Our ref: HA/2022/124099/01-L01
Your ref: P/46/22/PL
Date: 22 April 2022

DEMOLITION AND ERECTION OF 1 NO DWELLING WITH DETACHED GARAGE, HARDSTANDING AND LANDSCAPING. THIS APPLICATION IS IN CIL ZONE 4 AND IS CIL LIABLE AS NEW DWELLING. 12 EAST FRONT ROAD PAGHAM PO21 4SU

In the absence of an acceptable flood risk assessment (FRA) we **object** to this application and recommend that planning permission is refused.

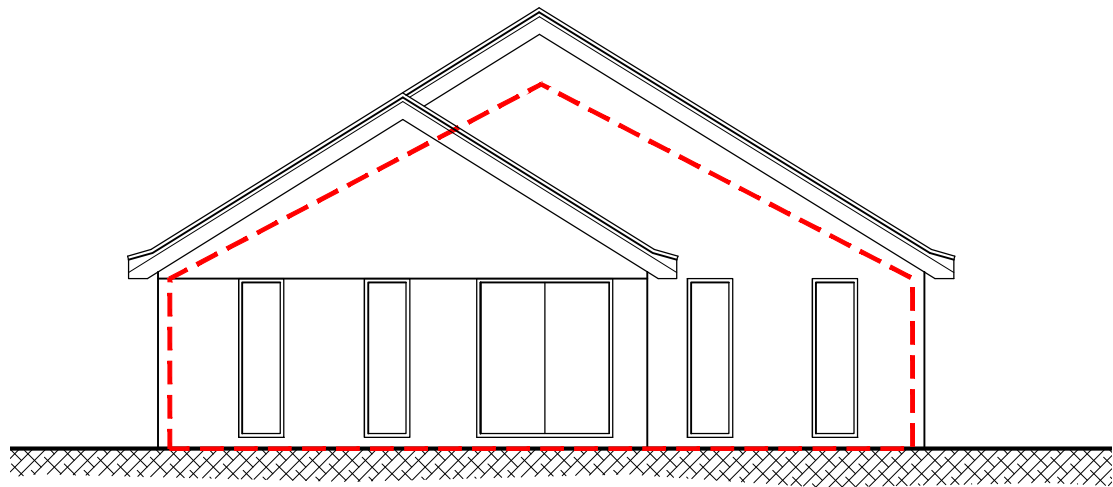
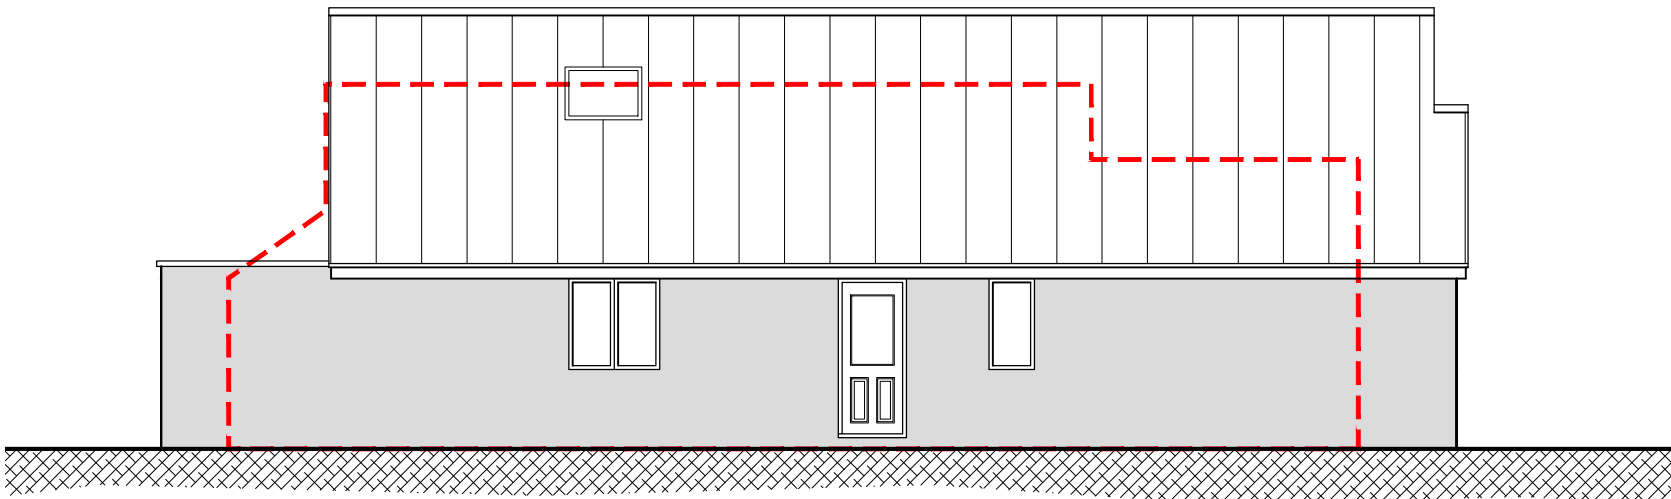
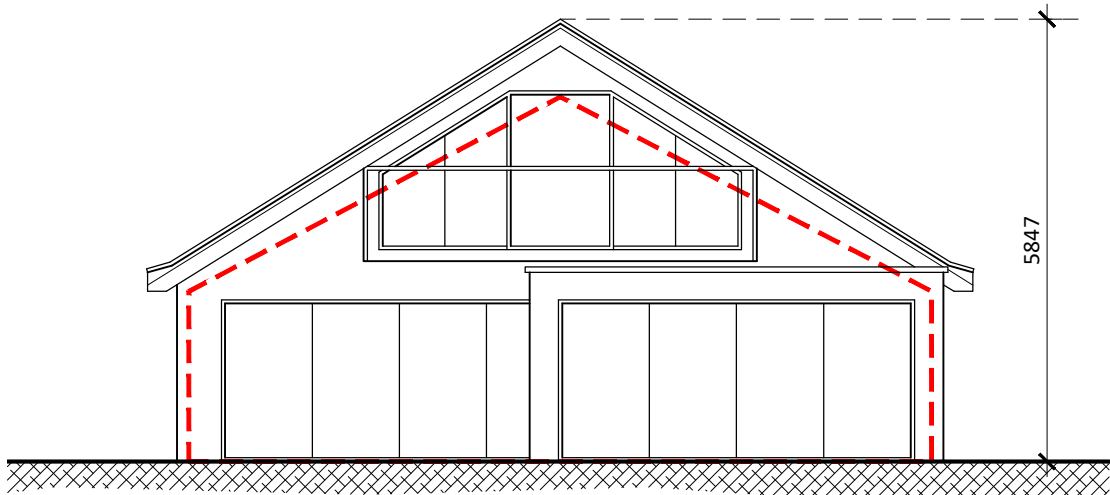
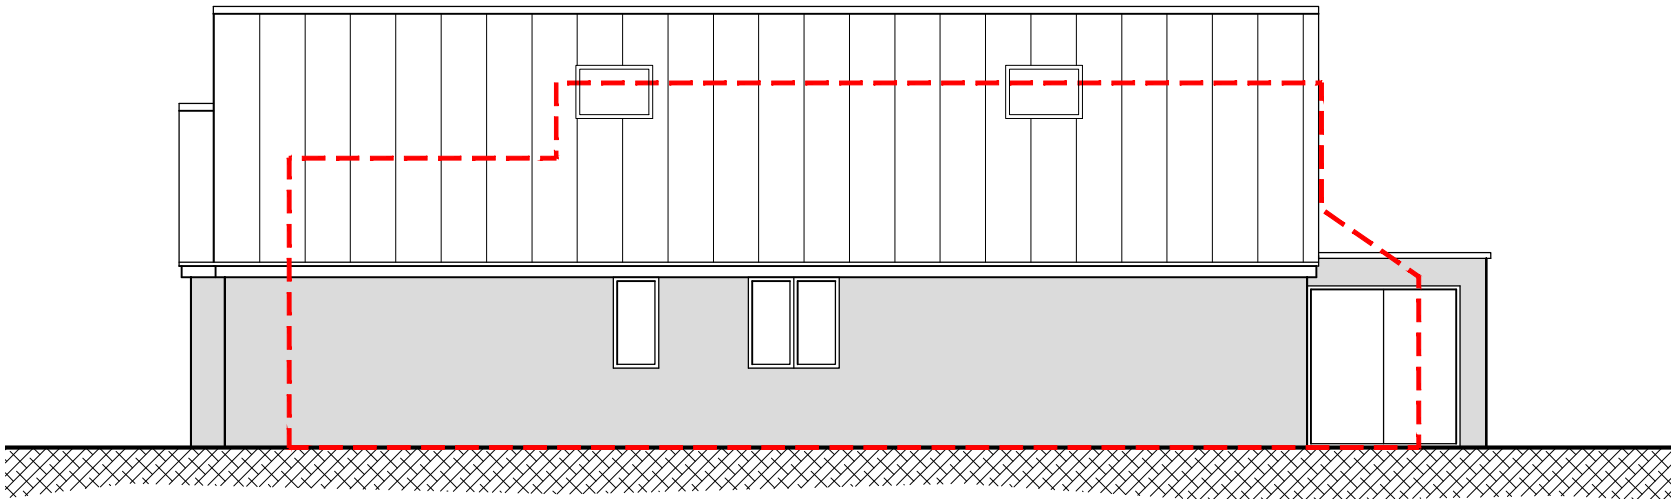
- Take the impacts of climate change into account. We would advise the applicant to look at the guidance on Climate Change Allowances.
- We would also strongly advise that the Finished Floor Levels be no lower than the previous level of 5.78mAOD. If this is not possible, it must be shown that the property is still safe from flood risk when Climate Change Allowances are taken into account.

To overcome our objection, the applicant should submit a revised FRA and amended plans which addresses the points highlighted above.
